WEST SUSSEX COUNTY COUNCIL CONSULTATION

TO:	Arun District Council FAO: Maria Tomalova
FROM:	WSCC - Highways Authority
DATE:	13 June 2019
LOCATION:	40 Elm Grove, Barnham, PO22 0HL
SUBJECT:	BN/39/19/PL 1 No. replacement dwelling.
DATE OF SITE VISIT:	N/A
RECOMMENDATION:	Advice
S106 CONTRIBUTION TOTAL:	£N/A

GROUND FLOOR
1:100

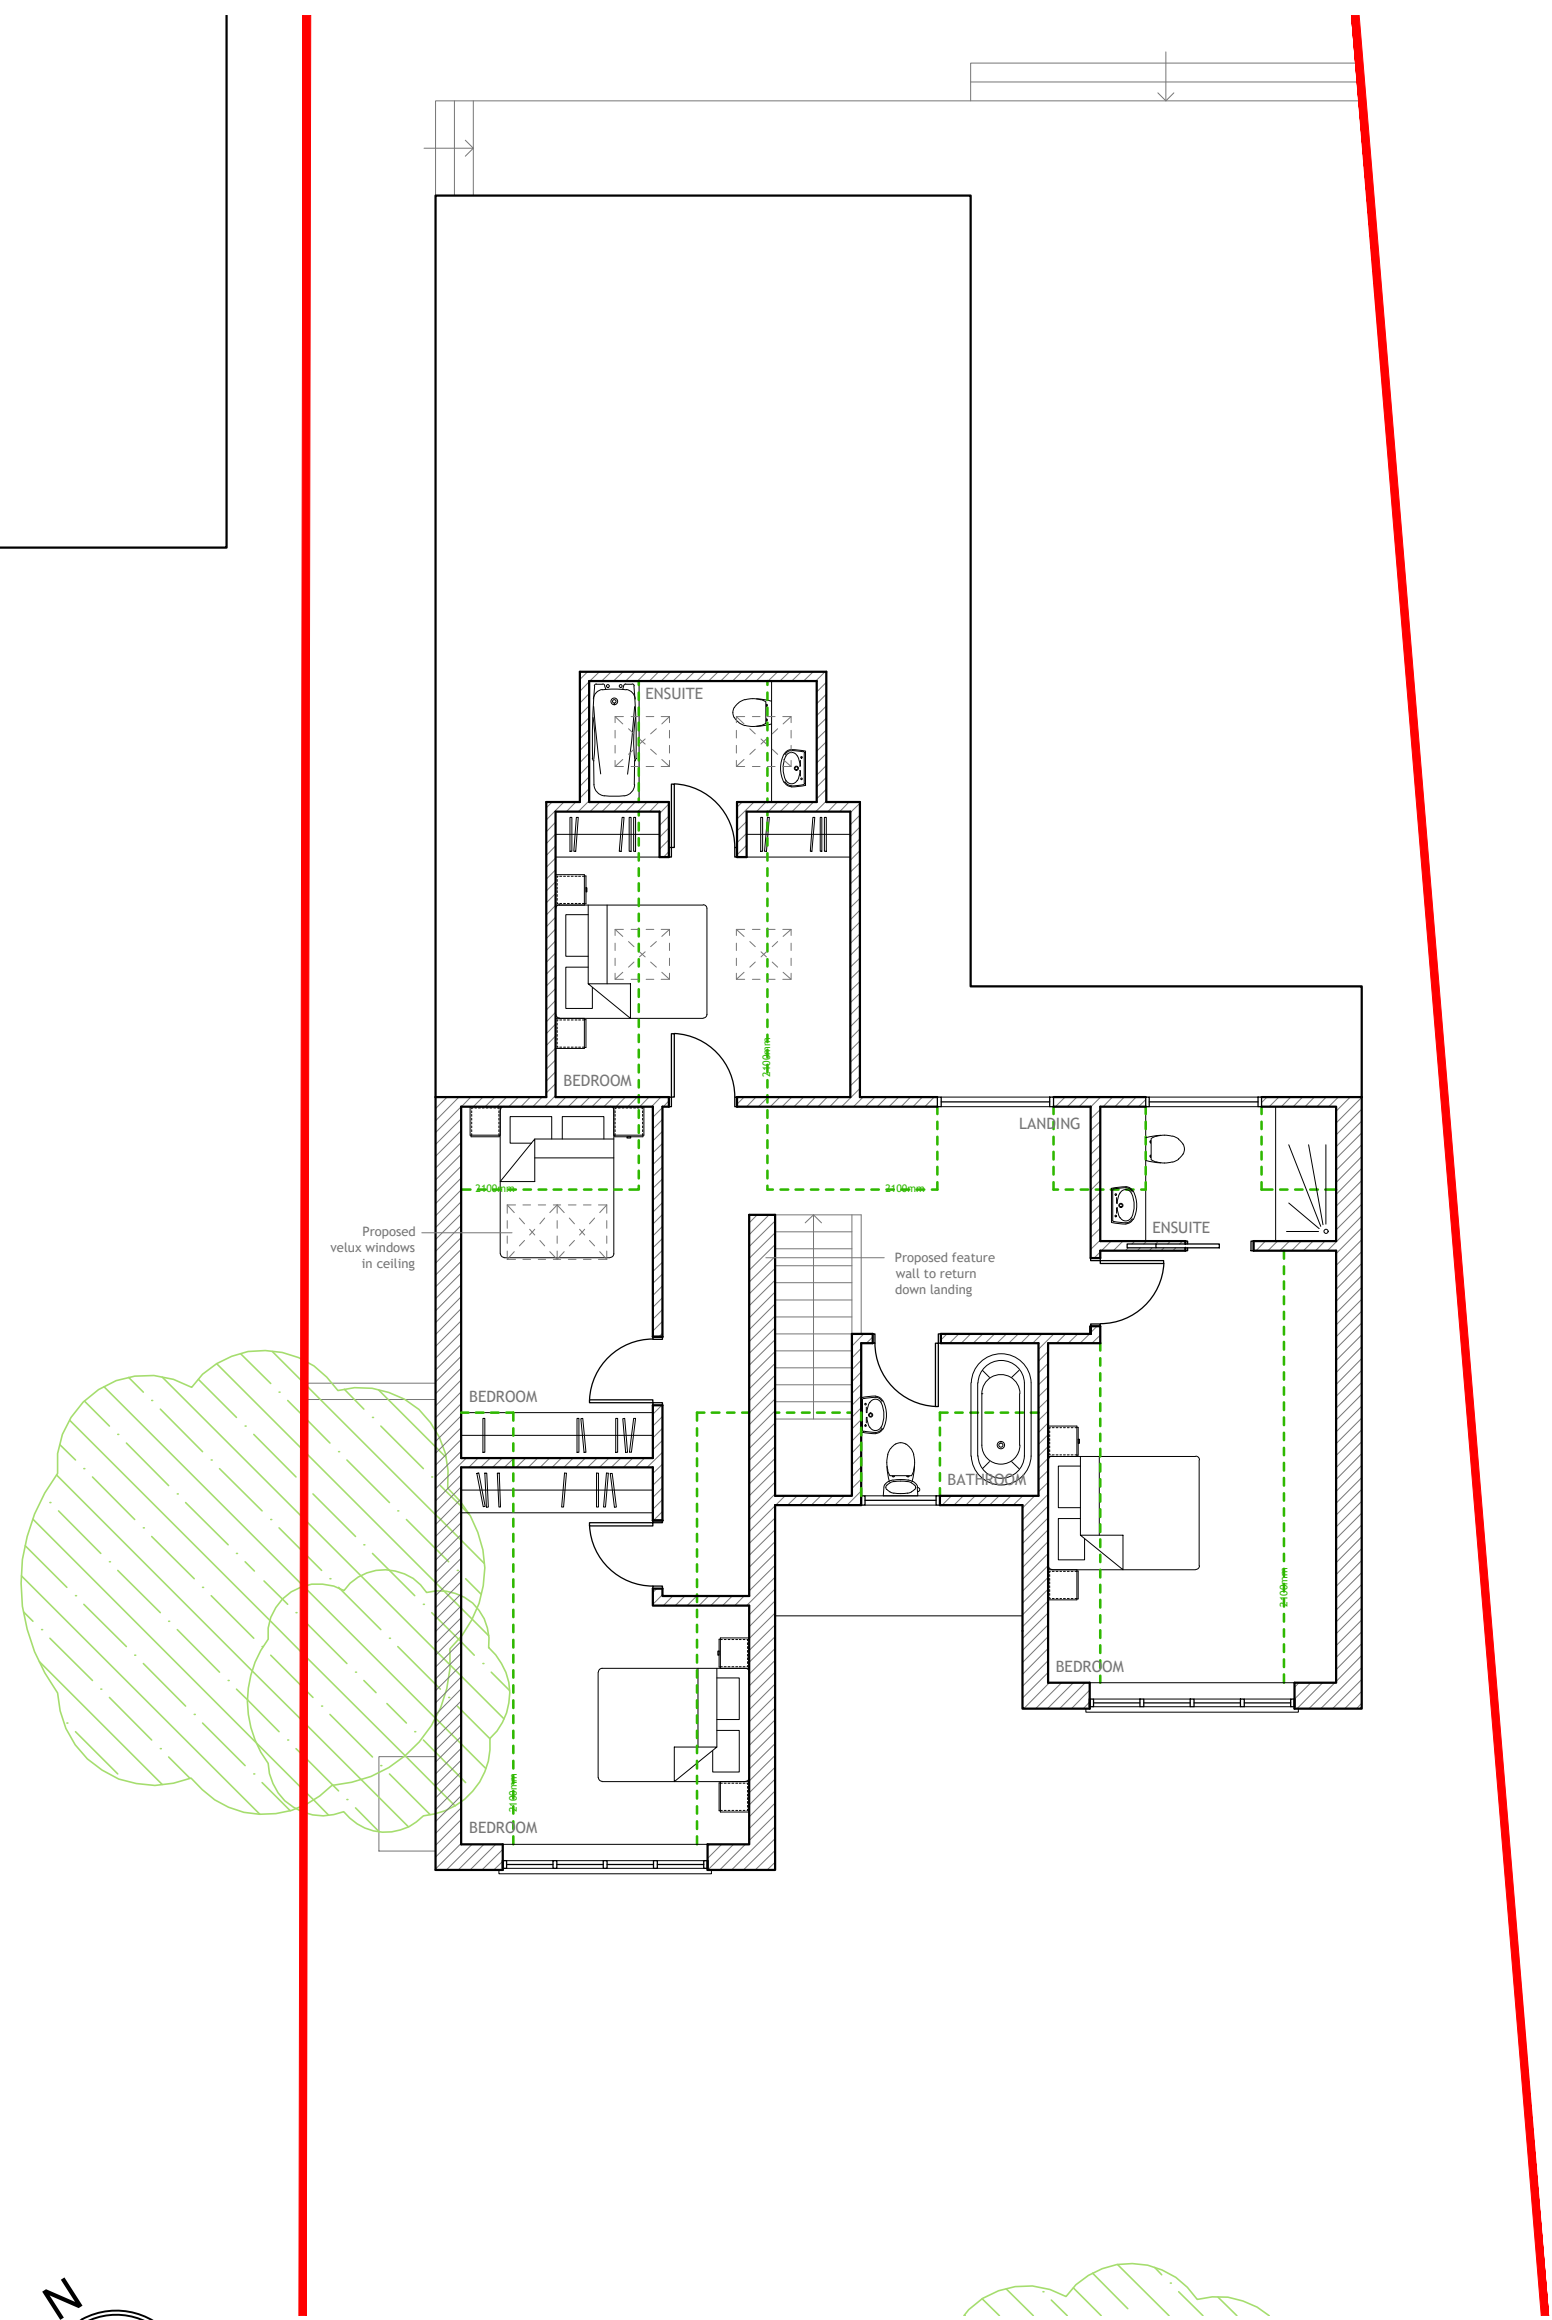
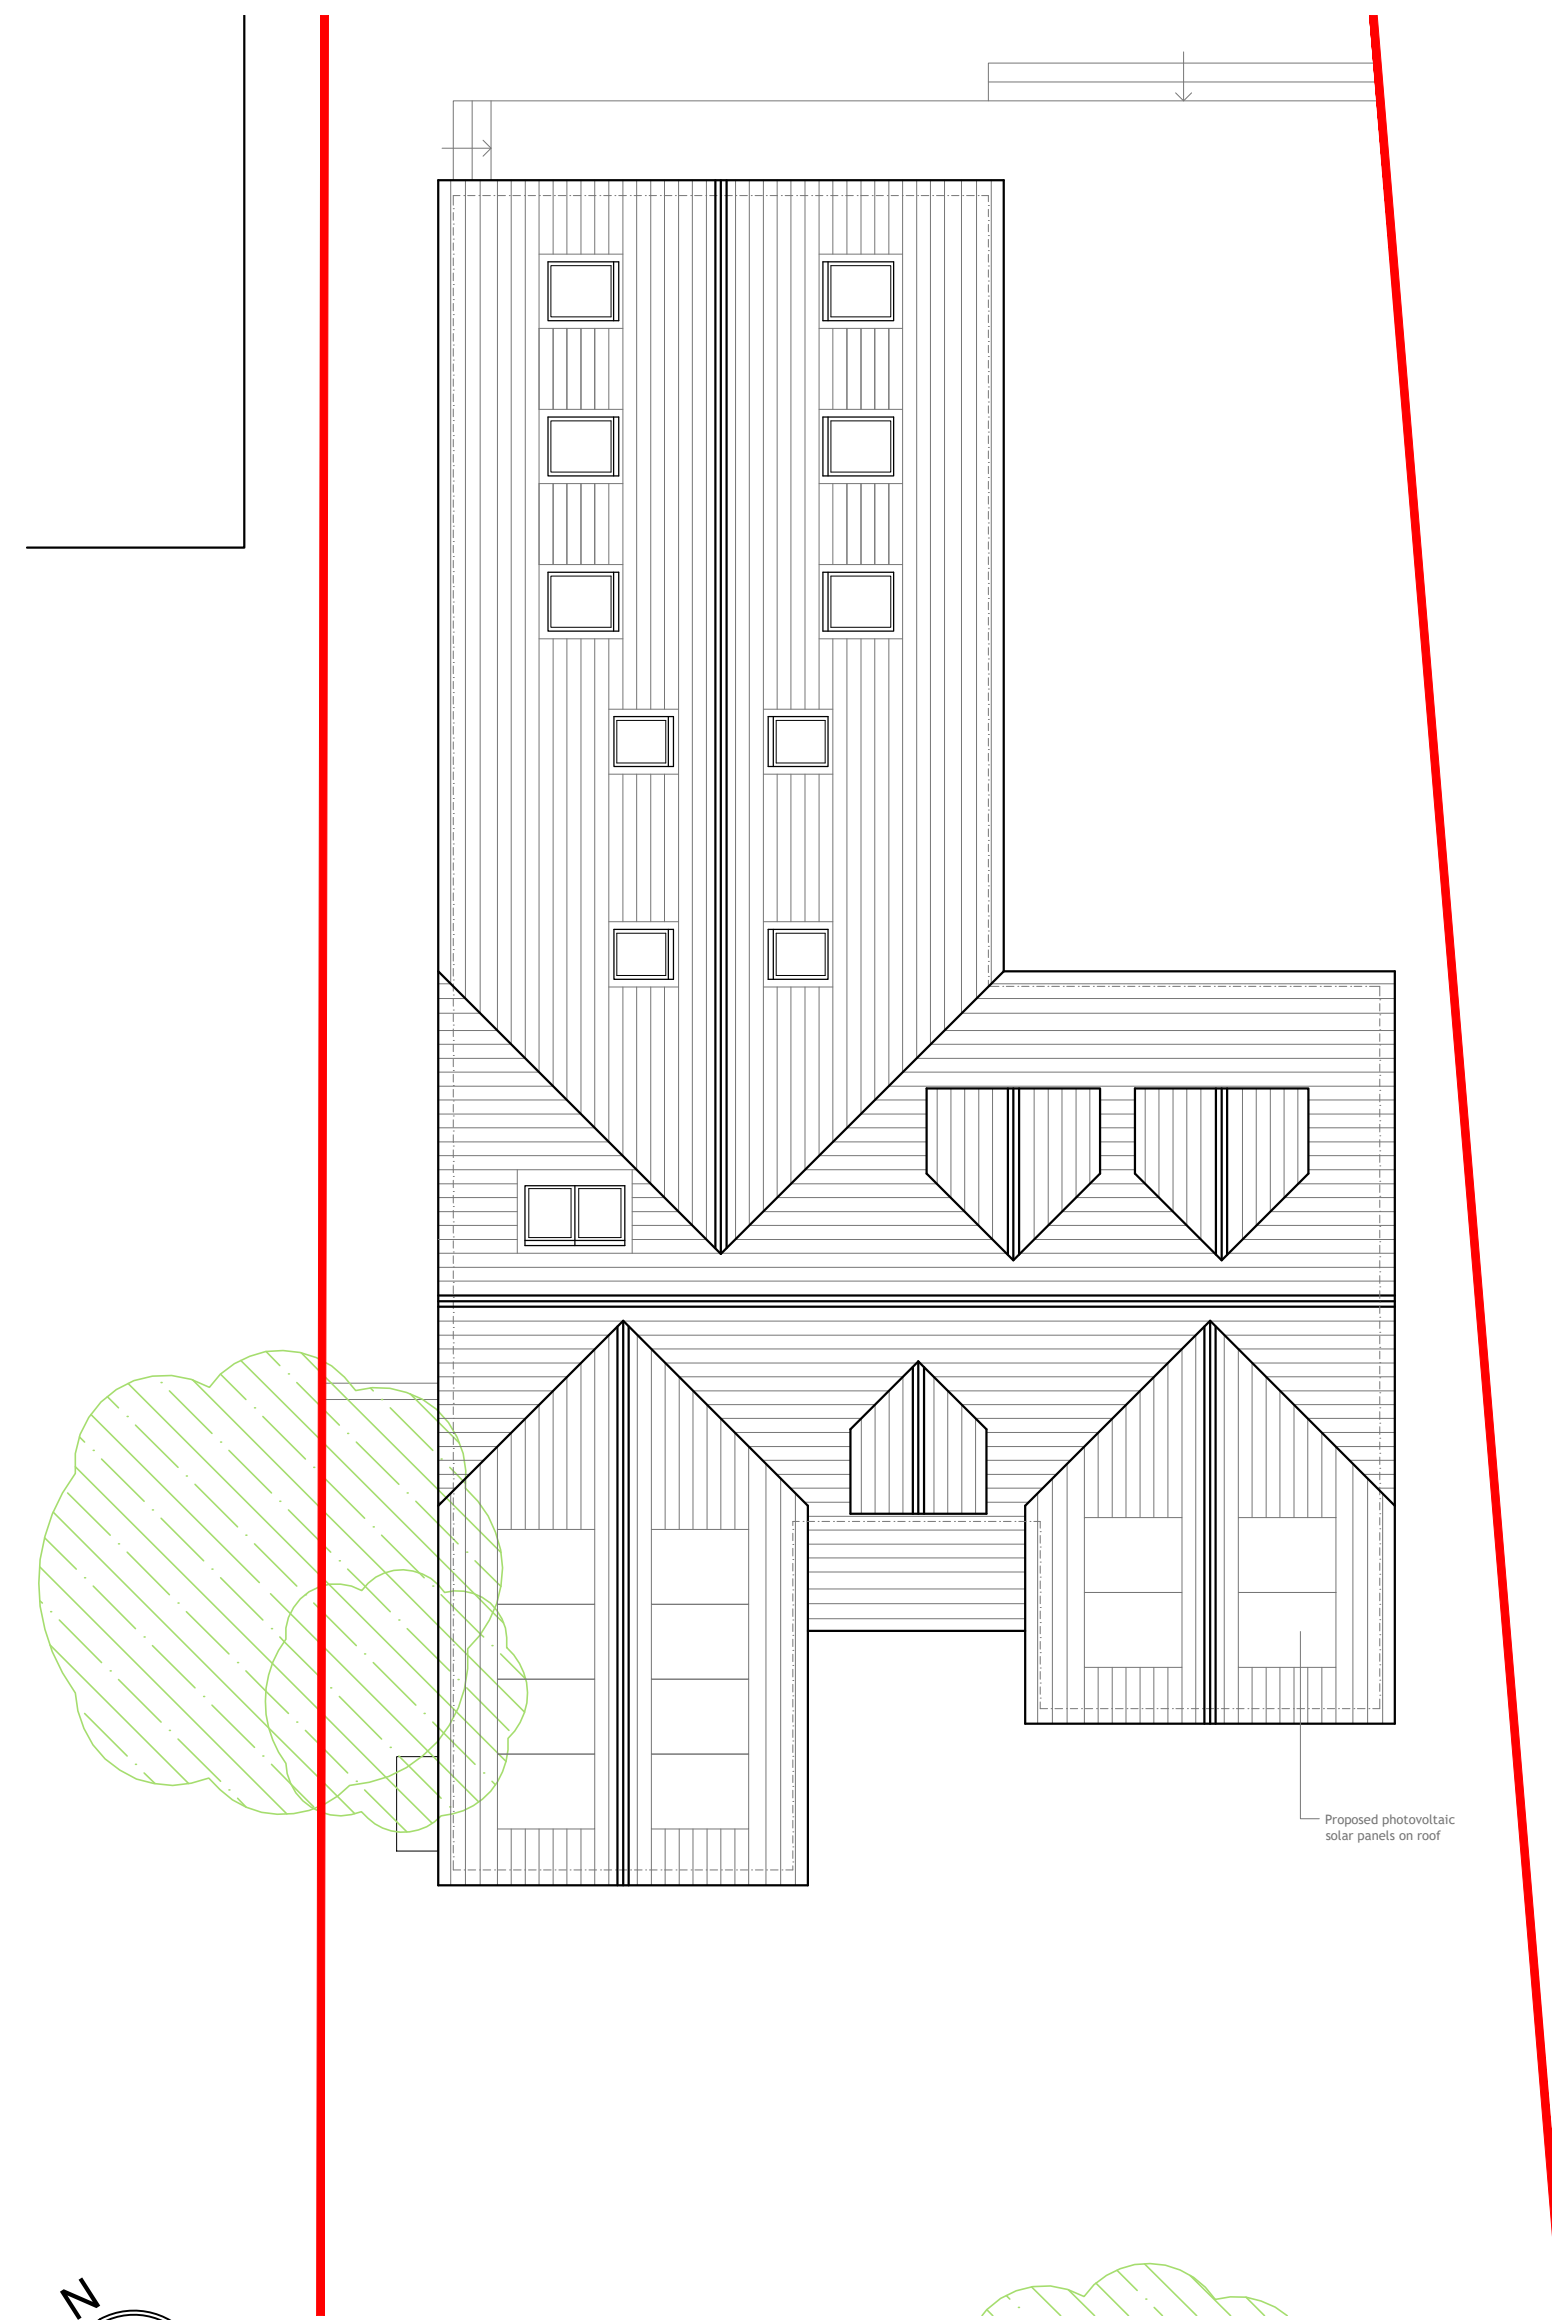
A new single car garage is proposed for the replacement dwelling. It will have approximate internal dimensions of 3.8m x 5.3m. The Local Highway Authority recommends revising the plans so that the garage meets the recommended minimum internal dimensions for single car garages of 3m x 6m as set out in Manual for Streets (MfS), to be considered for parking provision.
